From: Martyn White **On Behalf Of** Conservation Officer
Sent: 31 August 2018 11:24
To: Planning.Responses
Cc: Simon Davis
Subject: RE: Planning Consultation on: BE/76/18/HH

BE/76/18/HH

The proposal is for a single storey rear extension to a Locally Listed Building or Structure of Character. As such, the building can be identified as a heritage asset for the purposes of determining a planning application.

Description of Works: Single storey rear extension with pitched tiled roof (resubmission following BE/9/18/HH). This application affects the character & appearance of the Shripney Conservation Area.

Tel:- 01243 555208 enquiries@extendinghomes.co.uk	
TITLE:- Rear Extension @ 1 Old Moat Close Shripney Lane Shripney West Sussex GU9 8LX	
DATE:-	30th June 2018
SCALE:-	Elevations 1-100
DRAWN:-	P.Robinson
DWG. No. 1803661/PL/1

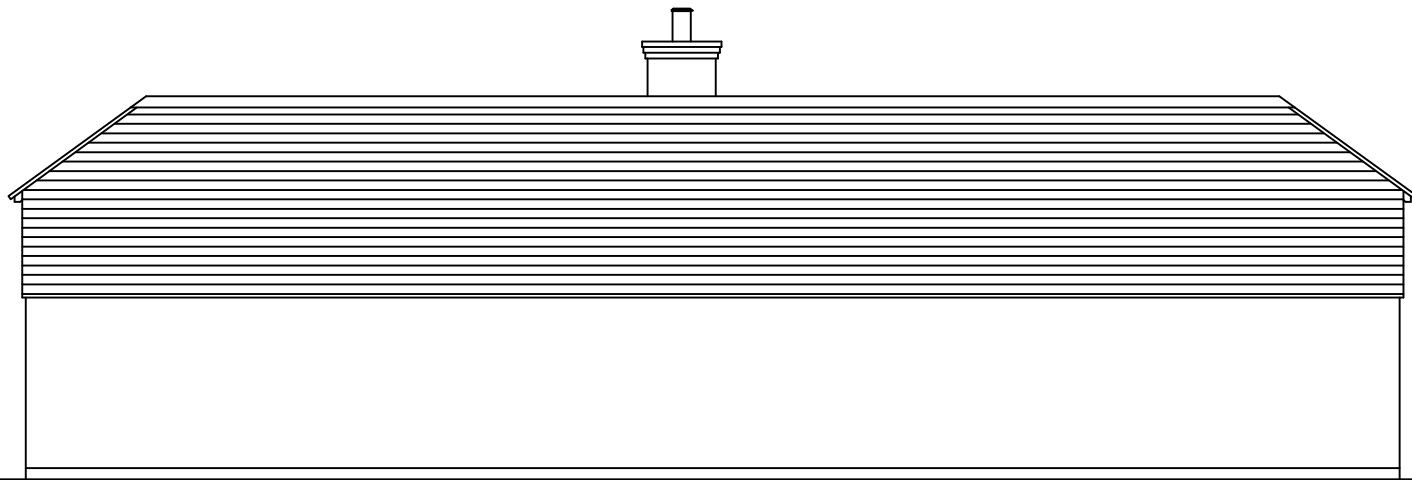
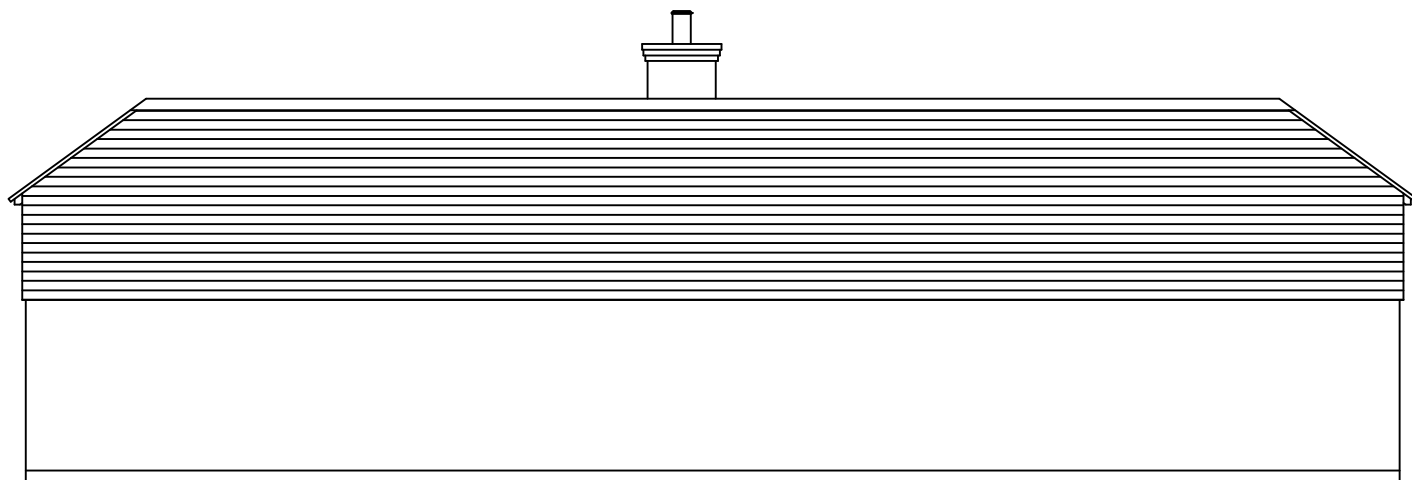
It is considered that the proposed extension provides the opportunity to improve living accommodation, whilst also being simple in appearance. It is considered that the new window/door design should respect those already present in order to ensure that the existing character is maintained. In addition, I note that two rooflights are proposed. Whilst these are acceptable, they should be of a conservation standard design. Details of the windows/doors/rooflights should be provided for by way of condition.
